Re: Certification Submittal for Final Building Certificate of Occupancy for
La Vida LLena Fitness Room, [F-21 / D28]
10501 La Lagrima De Oro NE
Engineer's Stamp Dated 10/02/06

May 8, 2006

**Re: La Vida Llena Fitness Room Addition, 10501 Lagrima de Oro Road,
Grading and Drainage Plan
Engineer's Stamp dated 4-14-06 (F21-D28)**

S-1

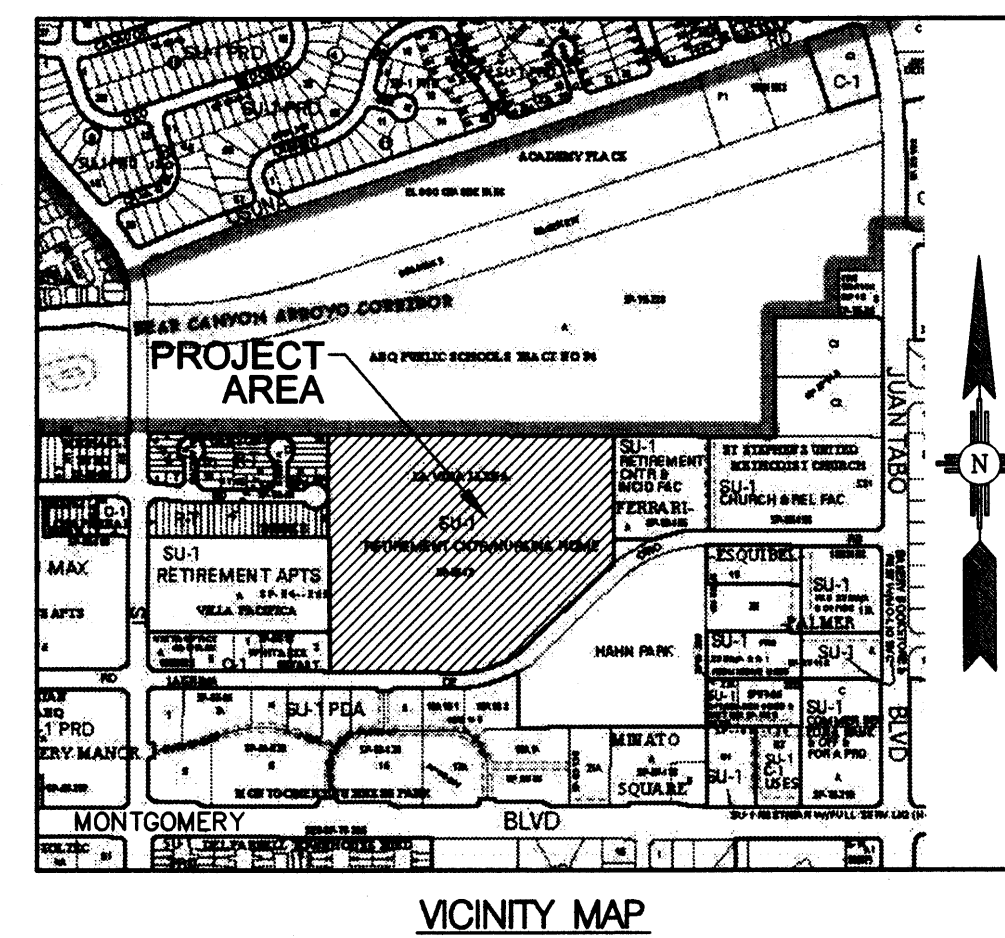
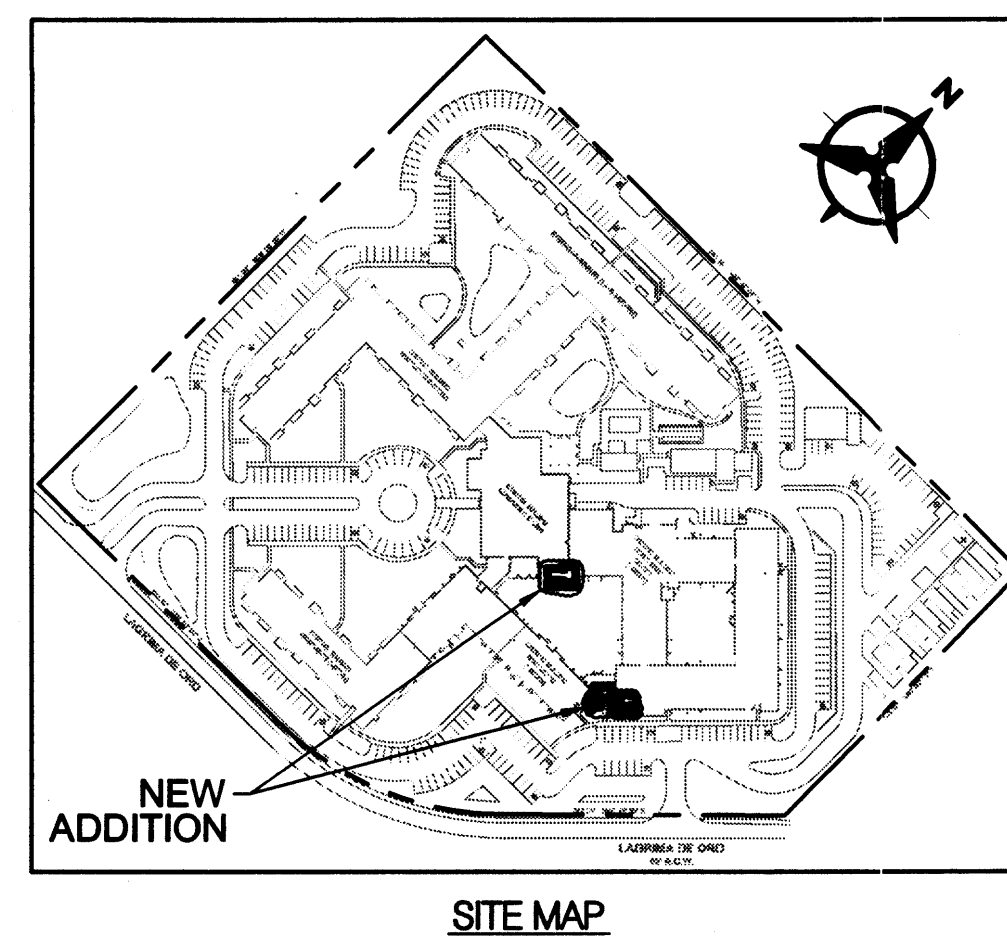
- Reference a nearby benchmark on the grading and drainage plan. Per the Development Process Manual, Chapter 27, Section 2, Part C, "Base all elevations shown on the plans on City of Albuquerque datum. (NSL, North American Datum, 1929)."
